Our Ref: CA/grc/2976
Your Ref: 6/2016/1855/VAR
E-mail: s.dicocco@welhat.gov.uk

45 Northaw Road East, Cuffley, EN6 4LU

The Applicant is agreeable to Condition 2 of planning permission Ref: 6/2016/0391/VAR being varied, rather than removed in its entirety, and to this end please find attached Drwg No. nor/plan/15 Rev 1 dated November 2016 which provides full details of the windows at roof level.

Side Elevation (South facing) Proposed

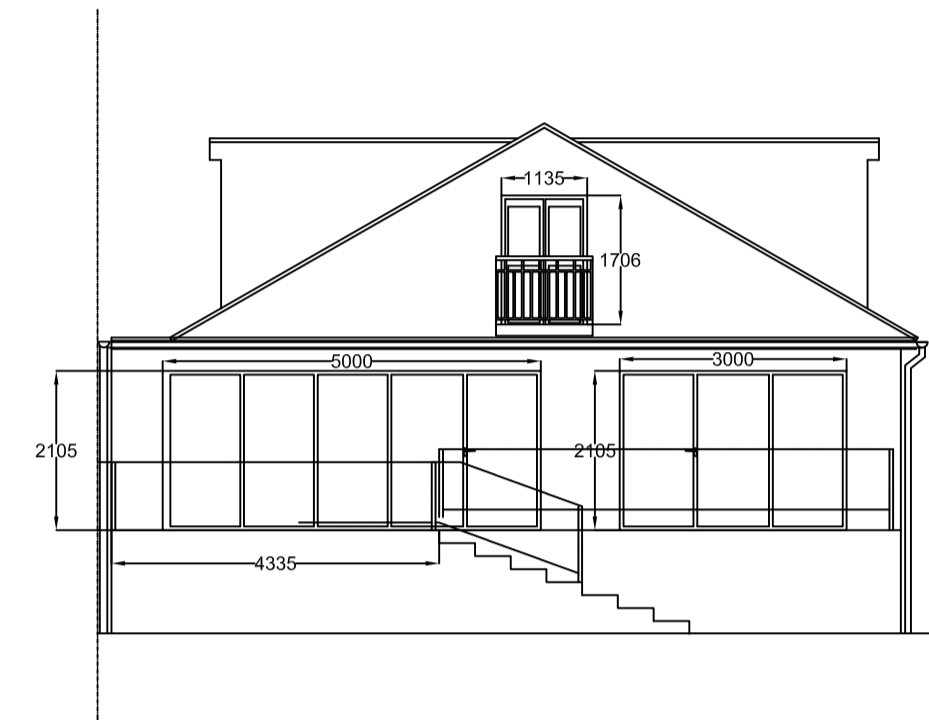
You have agreed that it is not necessary for obscure glazing/limited opening on the south facing elevation given that those existing windows on that elevation do not overlook any habitable room windows. There is already obscure glazing to the bathroom window at the rear of the application premises on that side of the building in accordance with the detail on the plan as approved under application Ref: 6/2015/2223/HOUSE). The front bedroom window on that elevation overlooks a roof light to a garage, not a habitable room (as you have acknowledged). The middle window is to the staircase. The bottom of that window is 2.61m above stair height and thus in any event is above the 1.8m referred to in Condition 2 of permission Ref: 6/2016/0391/VAR. Furthermore even from the landing, beyond the staircase, as you witnessed yourself all that could be seen through that window is unbroken tiled pitched roof. The rear most window on this elevation is to a bathroom. This is fully obscured. As you have seen yourself even when this is completely open all that can be seen is a flat roof.

Rev	Details	Date
MD DESIGNS UNIT 4 BAIRD RD, ENFIELD MIDDX, EN1 1SJ 01992 630 520		
CLIENT	Mr & Mrs Anklesaria	
LOCATION	45 Northaw Road East Cuffley EN6 4LU	
PROPOSAL	Window detail	
Date:	November 2016	
Scale:	A1@1:100	
Dwg:	nor/plan/15	1

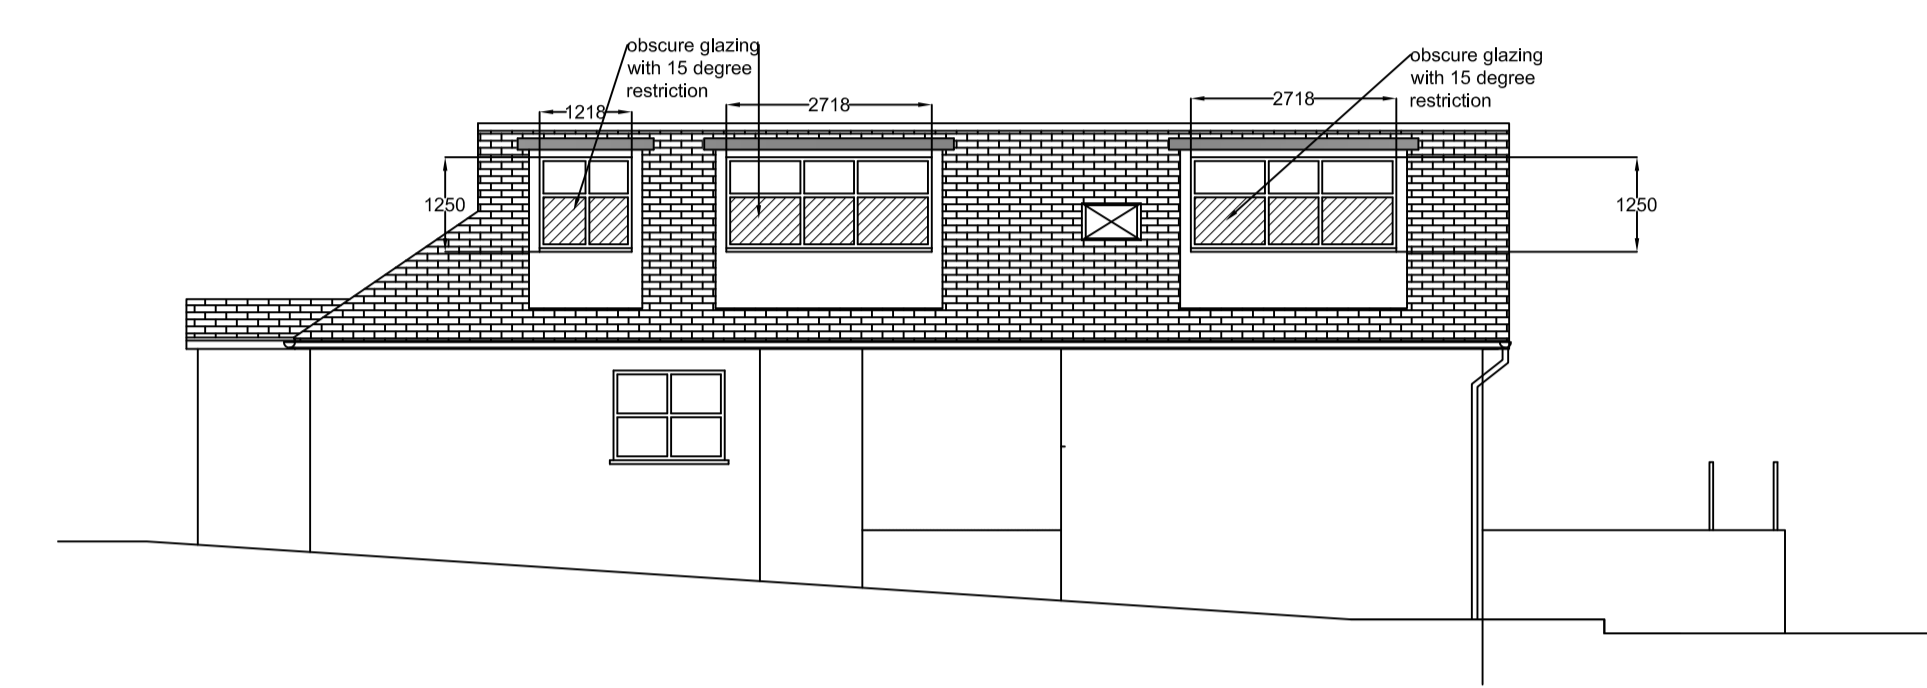
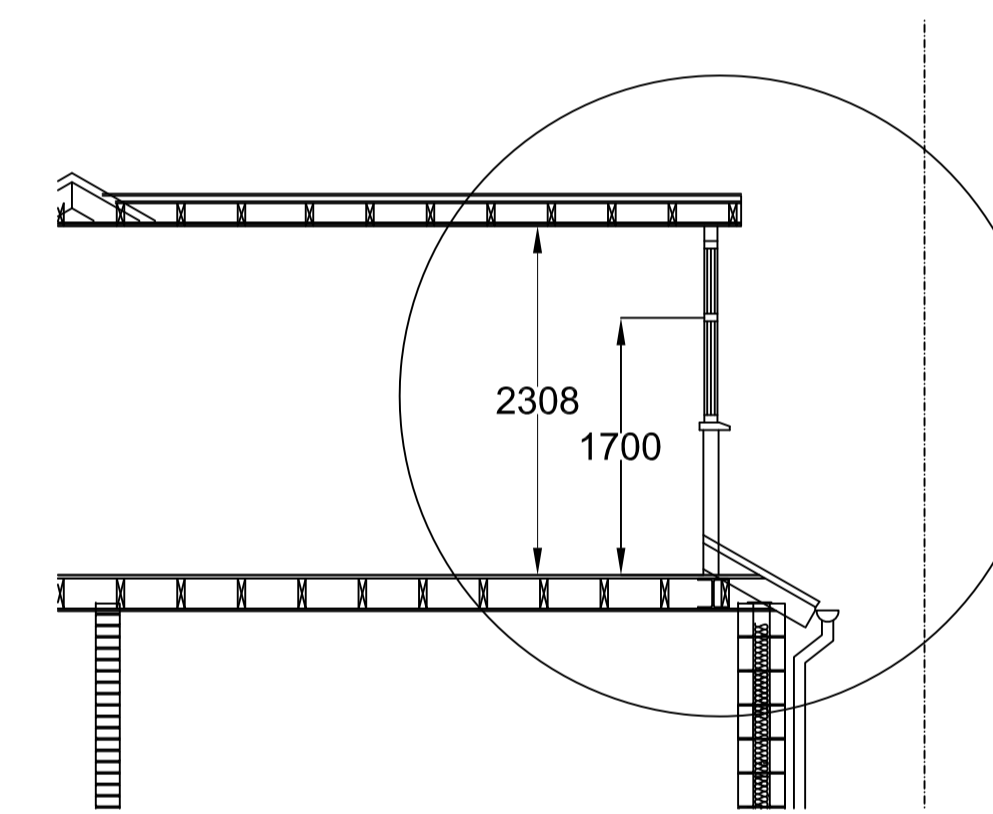
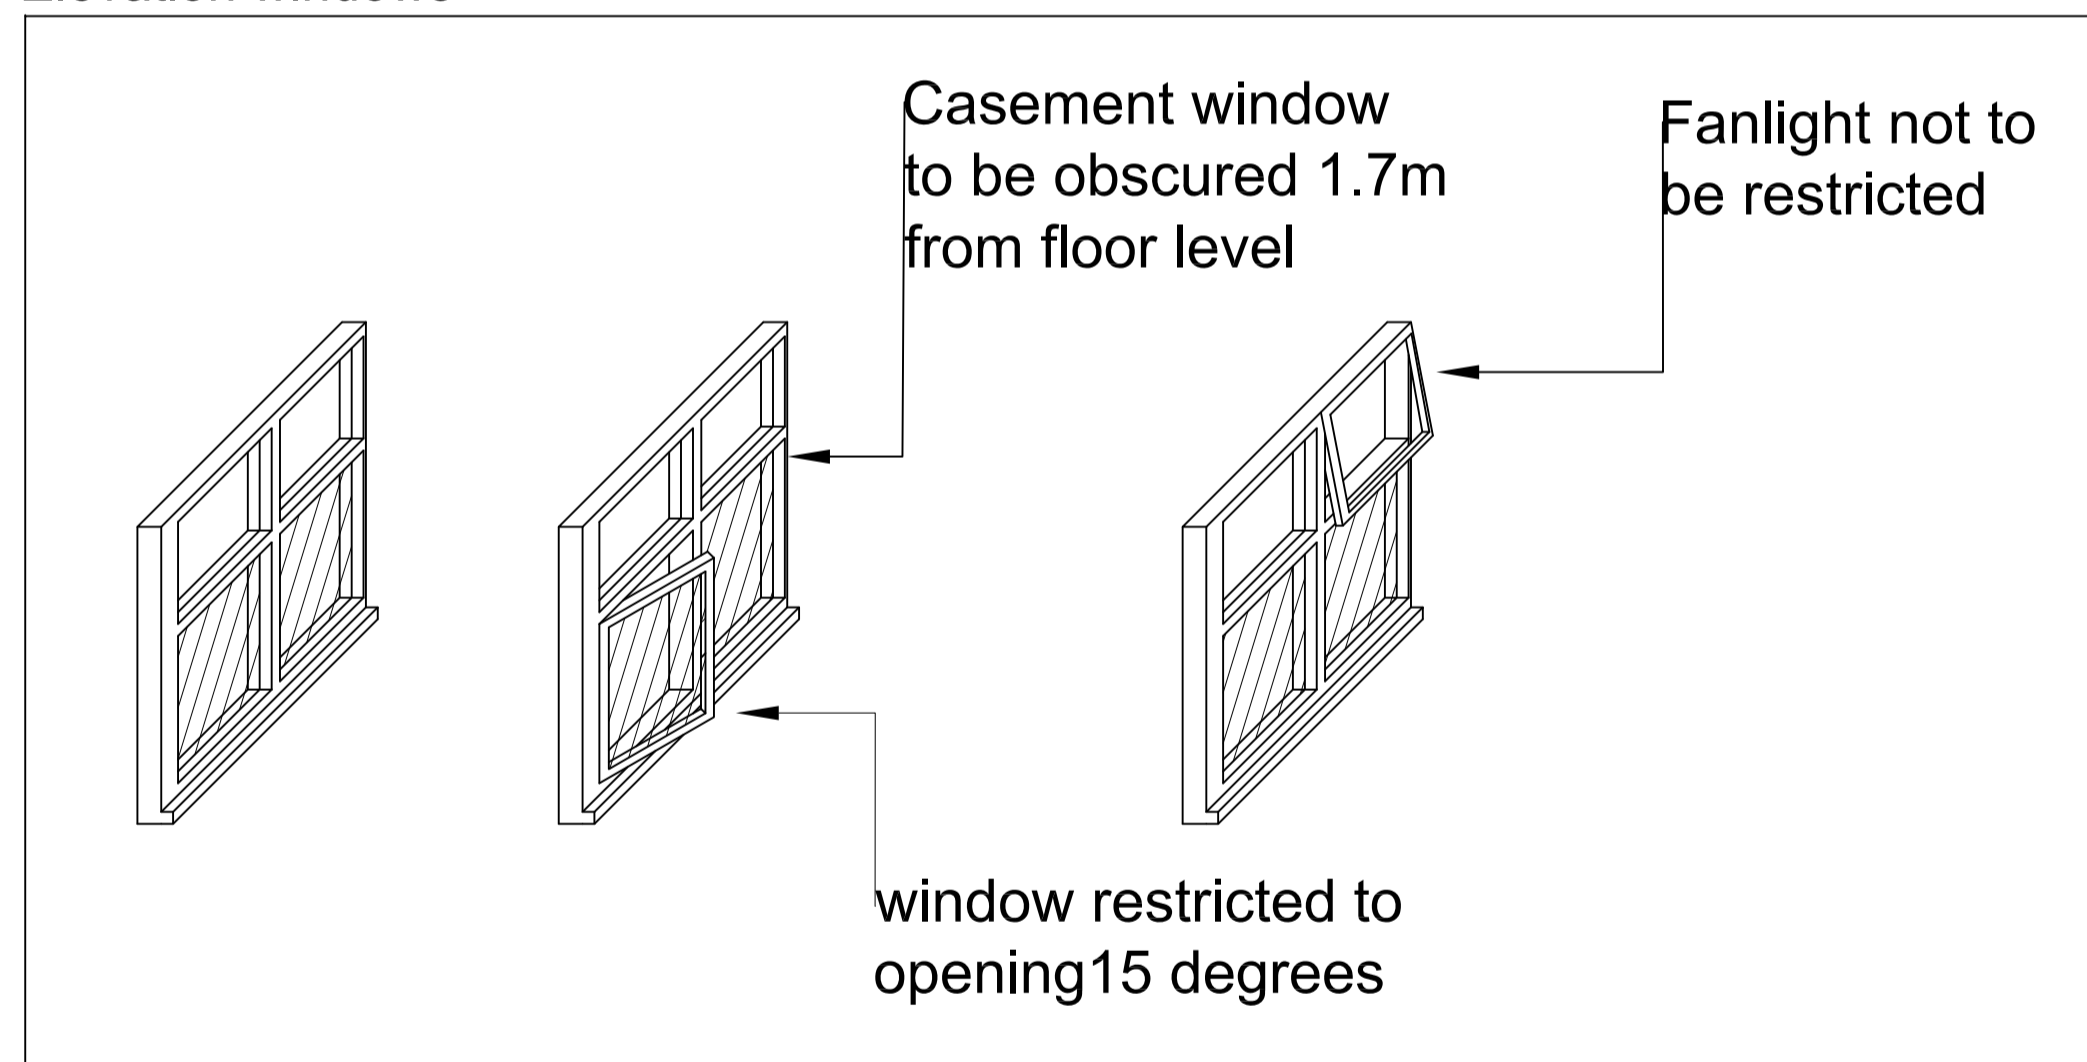
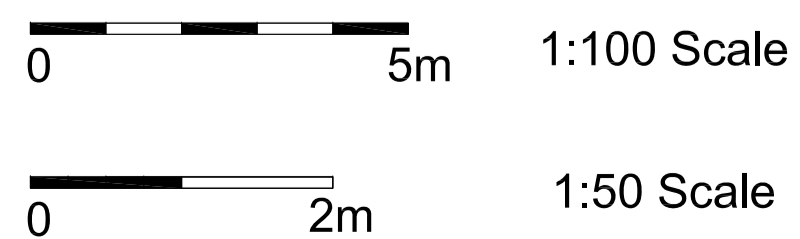
All windows on the north facing side elevation shall be fitted with obscure glazing below a height of 1.7m above finished internal floor level. All openable windows below that height should have restrictors fitted limiting opening to 15 degrees (in accordance with the details shown on Drwg No. nor/plan/15 Rev 1 dated November 2016).

The windows on the north facing elevation (ie; those which you raised concern about) are shown as having obscured glazing on all elements (openable and non-openable) below fanlight level. This will be 1.7m above finished internal floor level. 1.7m is the height that is generally accepted by all Local Authorities as the necessary height for obscure glazing, privacy screens or similar when the requirement is to ensure no impact on a neighbours privacy.

All window elements below this 1.7m height will either be fixed closed or, where there is a casement window, will have a restrictor fixed to it (details also included on the plan). This will restrict the window opening to 15 degrees which will assist in the necessary natural ventilation to comply with Building Regulations requirements whilst, at the same time, ensuring that the openable windows cannot be opened to a degree that would enable any overlooking.

There is no need for such window restrictors to the fanlights as these are all above eye level.
